FULL

Reference: H16-0714-21 **Date of Decision:** 18th August 2021
Applicant: Mr & Mrs D Roberts
23 St Annes Way
Spalding
PE11 3PN
Location: 23 St Annes Way Spalding
Description: Proposed two storey rear extension including alterations and garage conversion

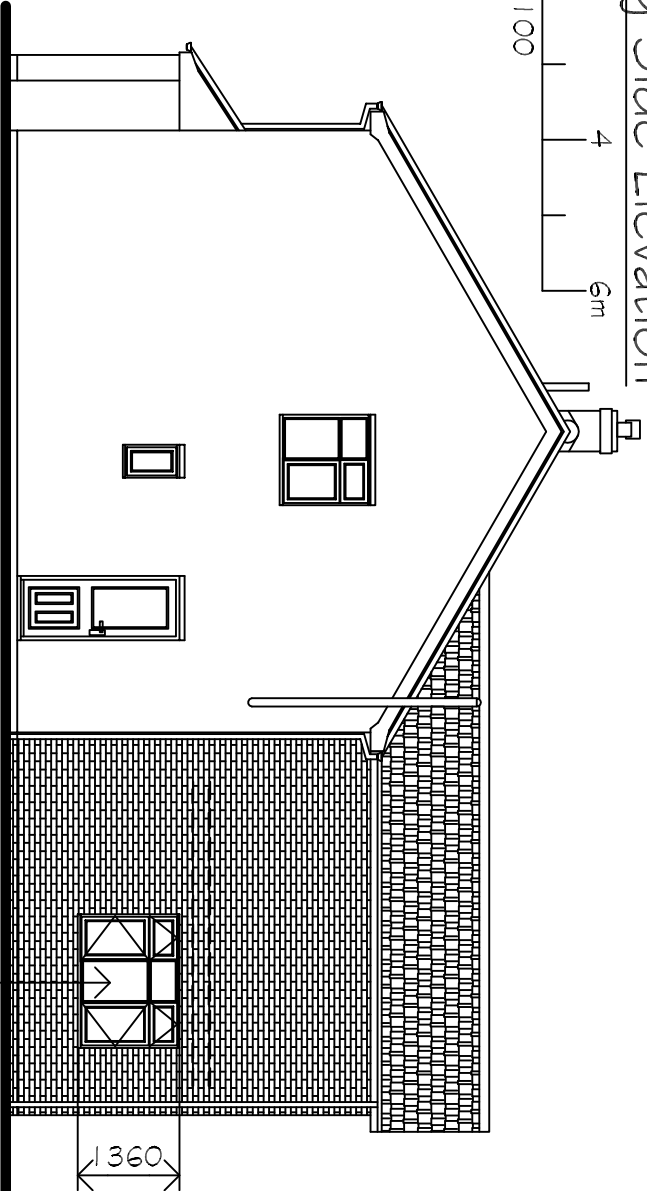
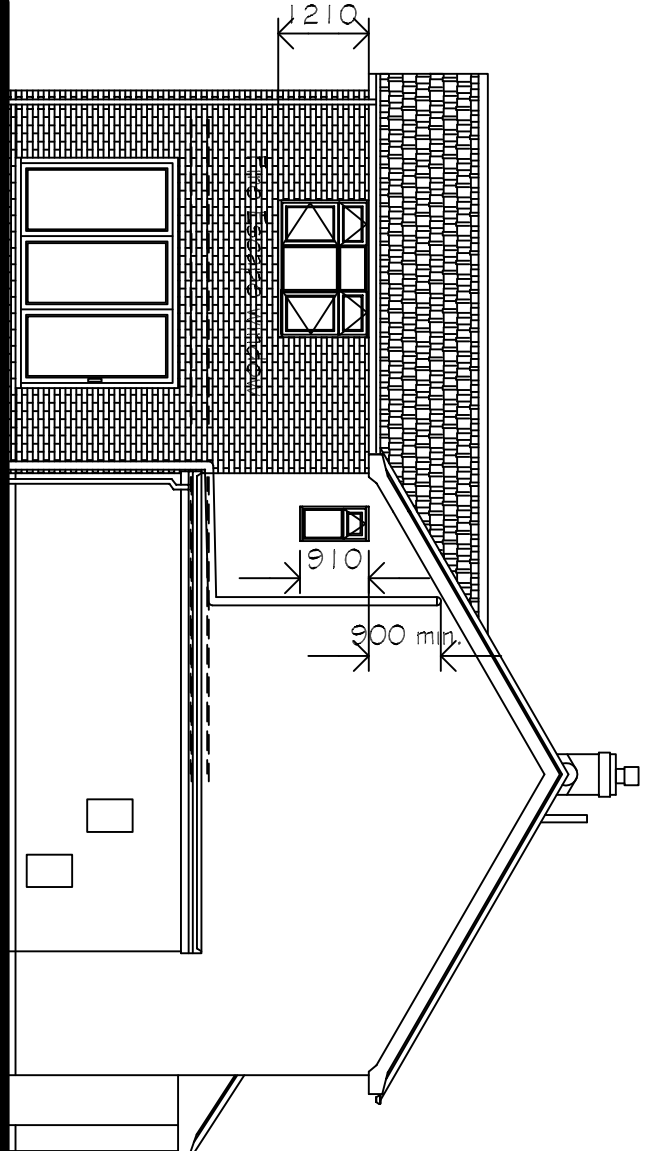
- 3 Notwithstanding the details submitted, the bedroom window in the eastern elevation shall be obscure glazed using Grade 4 glass and thereafter so maintained.
